# London Luton Airport Expansion

Volume 8 Additional Submissions (Examination)  
**8.61 Change Notification - Drainage Strategy**

**8.61 Change Notification - Drainage Strategy**

<b>Version</b>	<b>Date</b>	<b>Status of Version</b>
Issue 1	September 2023	Additional submission - Change Notification 01 (Drainage Strategy)

**Inset 2: Preferred and reserved treatment options (from DDS, Appendix 20.4 of the ES [TR020001/APP/5.02])**

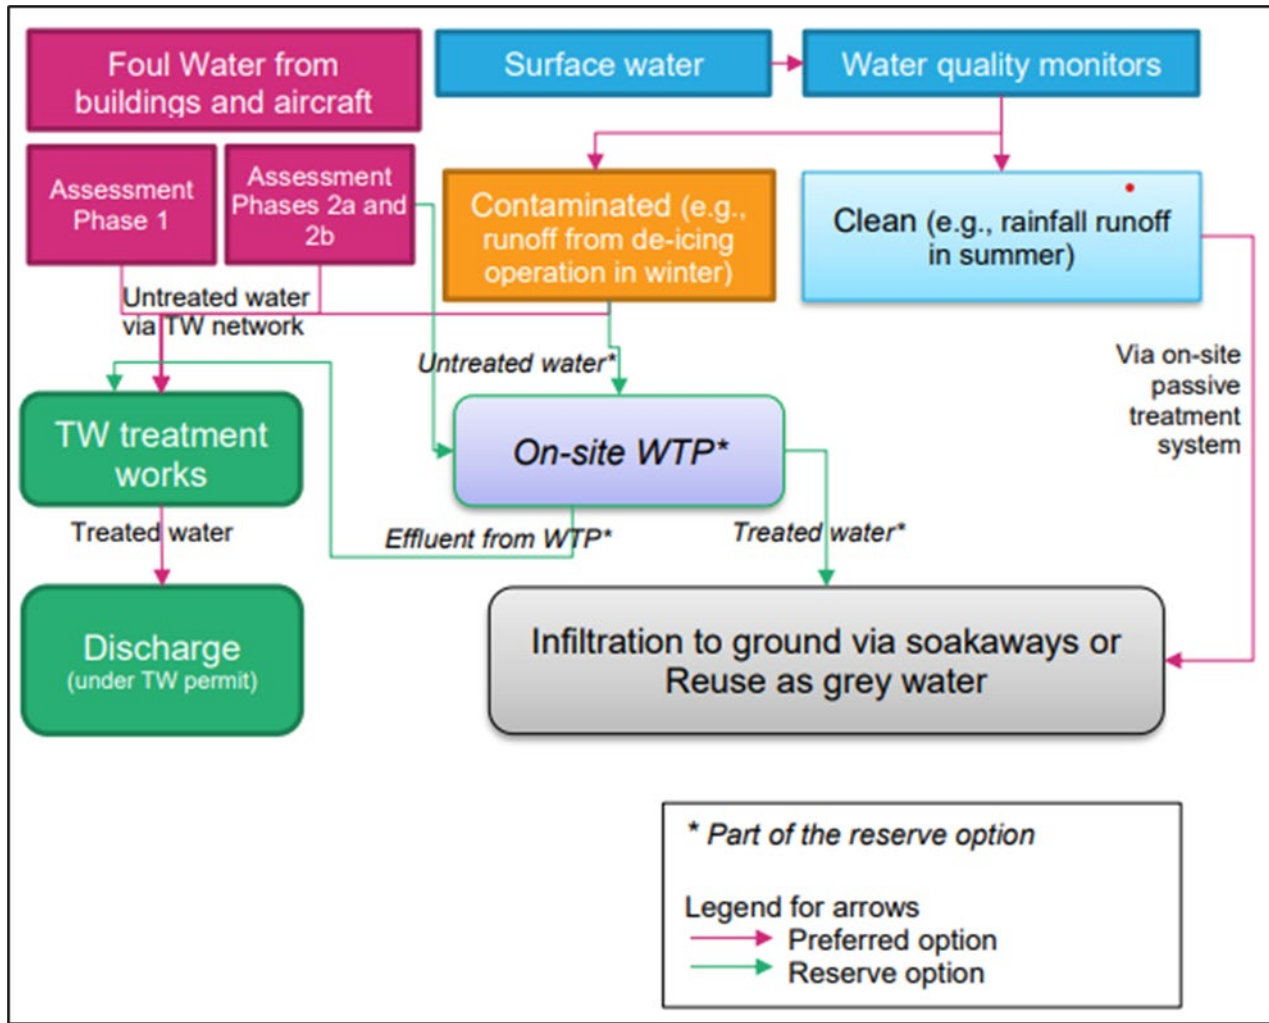
- 2.2.9 In response to the aforementioned TW correspondence, the Applicant now proposes a change to the **DDS [APP-137]** to provide that the Applicant's preferred option is to direct all contaminated discharges from assessment Phases 2a and 2b of the Proposed Development (including foul water from buildings, aircraft blue water<sup>1</sup> and contaminated surface water runoff) to the TW drainage, and treatment systems. As is the approach in the current **DDS [APP-137]**, non-contaminated (clean) surface water runoff would continue to be directed to groundwater by infiltration or reused as grey water.

- 2.2.10 This preferred option in the modified DDS would also recognise TW capacity and flow limitations: the modified DDS would propose using the attenuation tanks and other infrastructure, already included in the Proposed Development, to moderate and control the flow of contaminated discharges into the TW system.

- 2.2.11 The modified DDS would also recognise the ongoing nature of the TW assessment and the existing constraints at East Hyde Water Treatment Works. Given that TW's assessment of network and treatment capacity is ongoing, the Applicant's intention is to retain, in the DDS, the existing infiltration to ground options as a reserve option. This reserve option ensures a viable option exists for the treatment of contaminated discharges from assessment Phases 2a and 2b of the Proposed Development, should the preferred option prove not to be viable.

- 2.2.12 The modified DDS strategy, incorporating these preferred and reserve options, is illustrated in Figure 2-2.
